From: Contact Centre (CRM) <contact@ribblevalley.gov.uk>
Sent: 18 August 2025 21:16
To: Planning
Subject: Planning Application Comments - 3/2025/0580 FS-Case-741797695

Planning Application Reference No.: 3/2025/0580

Address of Development: Holmes Farm, Balderstone.

PROPOSED SOUTH EAST ELEVATION (1)

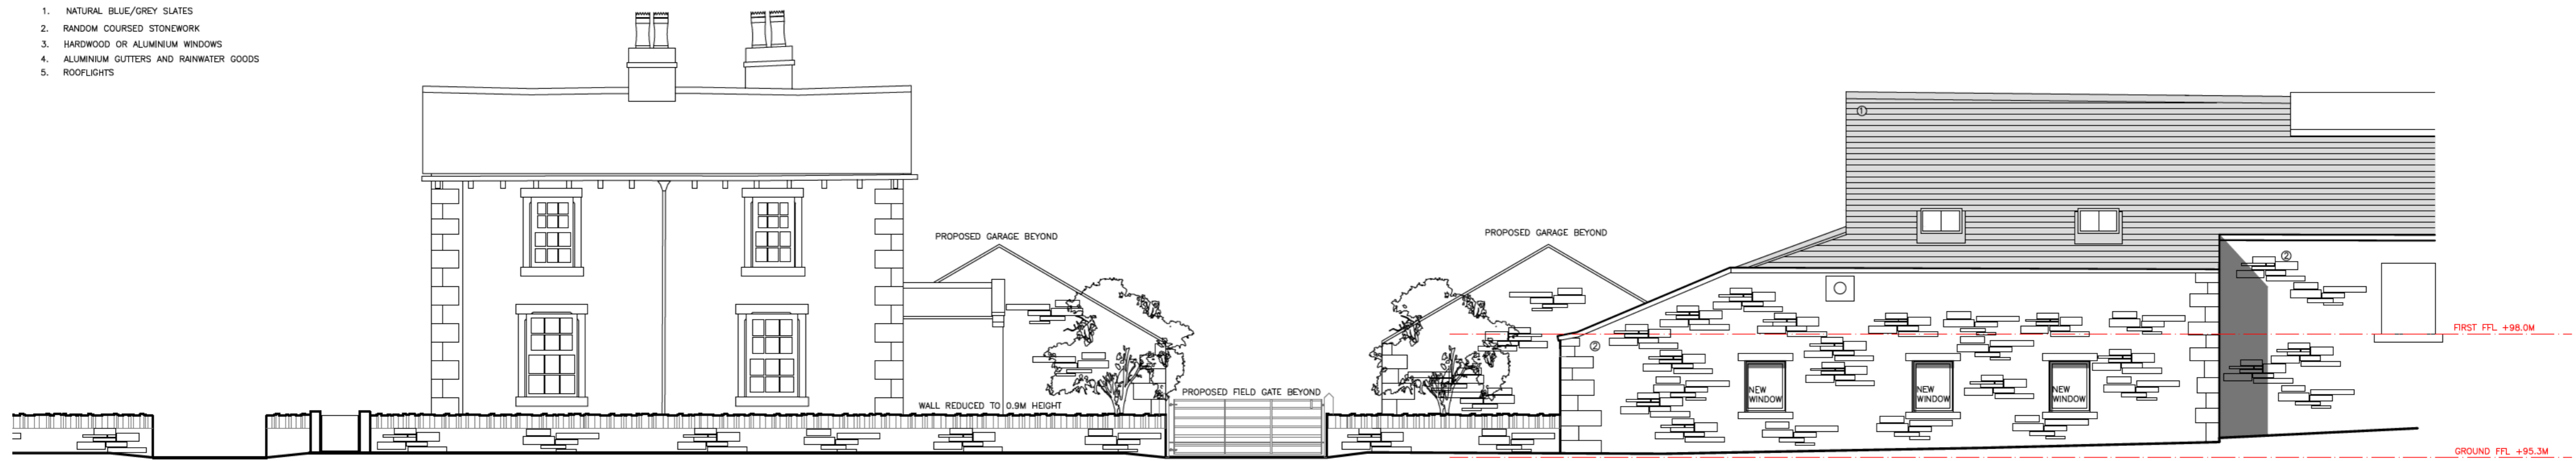
3. We note that there are plans to create new openings in the side of the barn facing the road. When [REDACTED], and, if so, what are the reasons.
